11 March 2026

TII26-135295

Re: Strategic Infrastructure Development (SID) Application for Battery Energy Storage System Development located in Knockraha, County Cork. An Coimisiún Pleanála. case ref. VA04.324082

Figure 2-5: Proposed Equipment Delivery Route

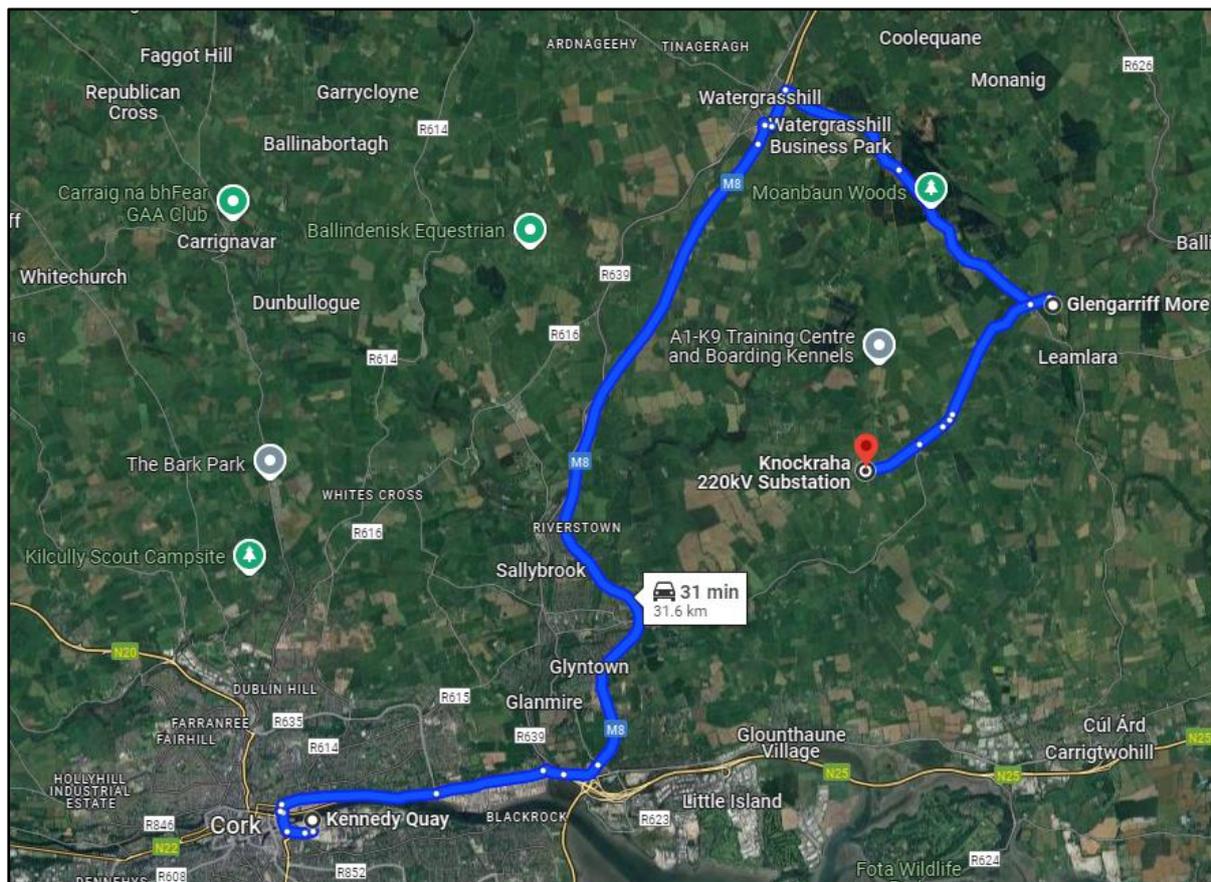
Section 3.4 Construction Traffic Haul Route of the "*Battery Energy Storage System, Ballynanelagh, Co. Cork Outline Construction Traffic Management Plan*" indicates that transportation to site of Abnormal Loads from port of entry at Kennedy Quay via the N8, M8 and Junction 17. While the assessments undertaken in relation to abnormal load delivery to site makes reference to a limited number of such loads are expected the applicant has provided no information provided as to an assessment that the capability of the network identified will be able to accommodate such loadings

nor temporary works to the national road network are identified which may be required as a result of this assessment.

1. Full details of the transportation of all Abnormal Loads and all 'Exceptional Abnormal Loads' associated with the subject development shall be agreed with all planning and road authorities along all proposed haul routes prior to the commencement of any development.

Such agreement shall include and address the following requirements;

a) The Exceptional Abnormal Load Vehicle diagram shall be provided to include Gross Vehicle Weight; Individual Axle Weights; Axle Spacing; and total vehicle length, width, and height. Exceptional Abnormal Load Vehicles shall comply with the standard configuration of a trailer with two bogies and two tractors; one pulling and one pushing as detailed within TII Publications AM-STR-06048.

b) All bridges to be crossed will need a full structural assessment by the developer in accordance with TII Publications AM-STR-06048 to verify that they can sustain the load safely and without any damage.

c) A Chartered Engineer with appropriate experience of assessing bridges for such Exceptional Abnormal Loads shall be required to certify that each structure to be crossed can sustain the loading regime safely and without damage. Appropriate Professional Indemnity Insurance shall also be in place.

d) Each local authority (who own the bridge assets and issue the load permits) shall be provided with an appropriate level of indemnity proportionate to the risk and the value of the bridge structures to be crossed.

e) Each local authority (who own the bridge assets and issue the load permits) shall be provided with insurance cover appropriate to the Risk and the value of the bridge structures to be crossed.

f) Pre-structural surveys and post-structural surveys will be required.
